You propose to erect a single storey outbuilding within the curtilage of your dwelling. As I understand it from the previous application this building is proposed to be for dependant relatives.

The design of the building has changed since your planning application and it has been reviewed by the Conservation Area as your dwelling is a listed building and the outbuilding would impact on the setting of the Listed Building. The Conservation Officer has responded and his response is as follows:-

2. ELEVATIONS

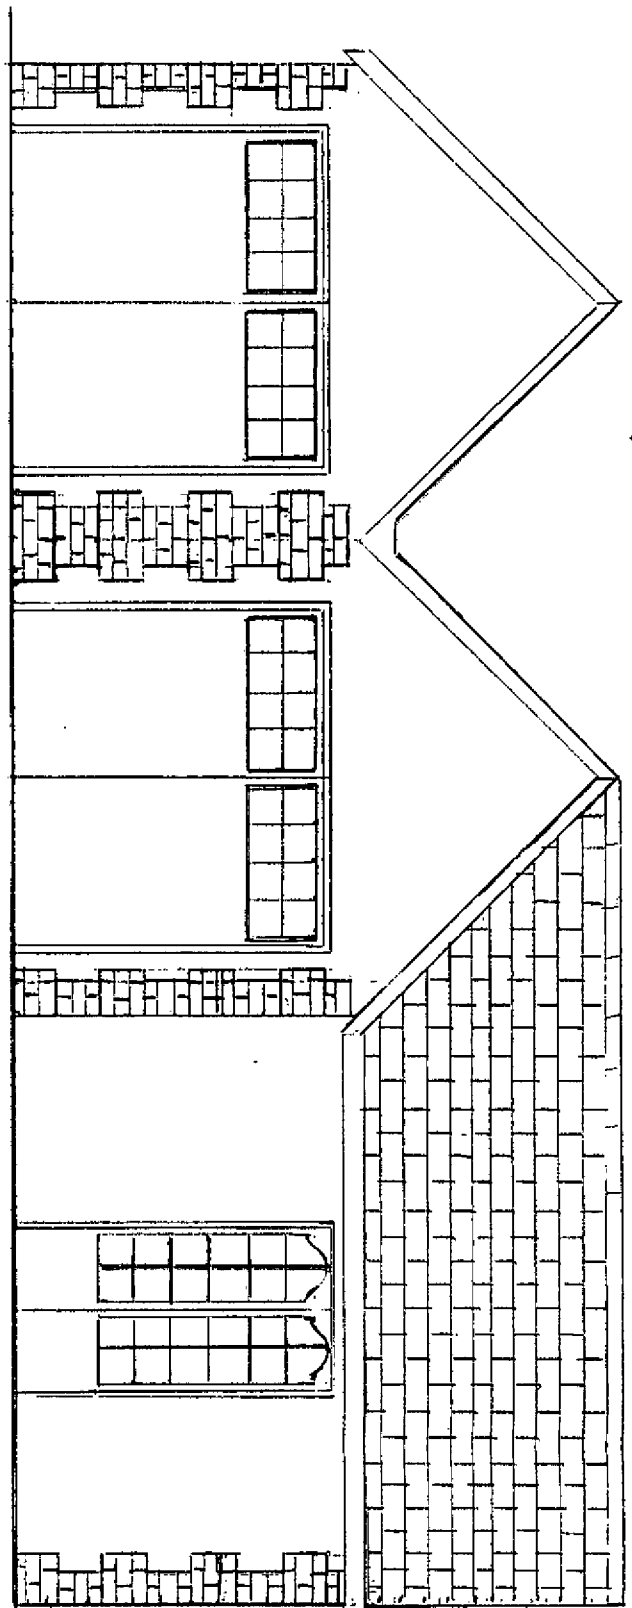
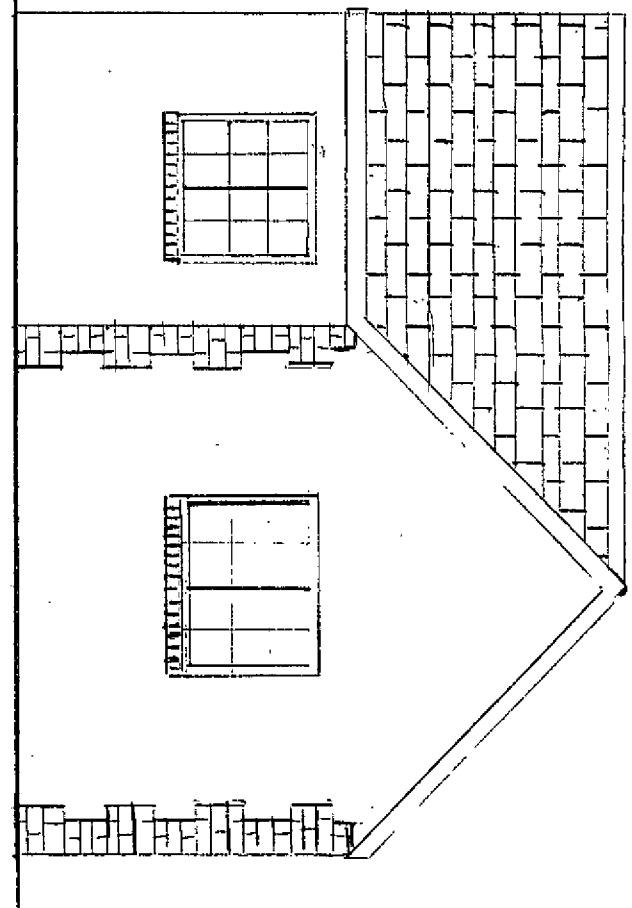
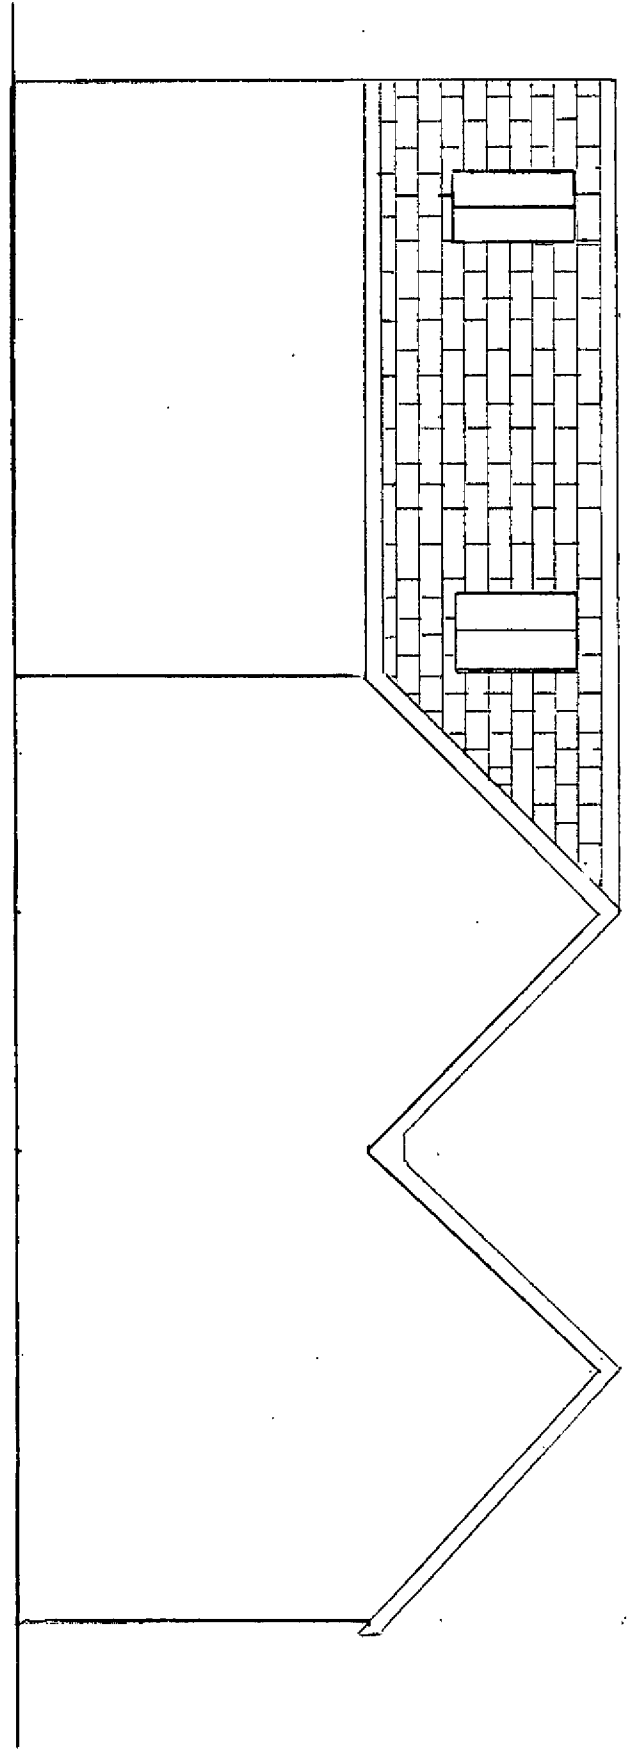
The existing garage is of masonry construction, and reflects the character of the existing dwelling. It is small scale, and as a consequence subservient to the main property.

It is considered that there is potential to extend the garage structure to provide for the required accommodation. However, any new works should closely reflect the existing structure in terms of scale and appearance.

The building should still read as a standalone garage outbuilding (more akin to option A), so that it reads as a subservient standalone structure, and maintains the appearance of the existing garage structure."
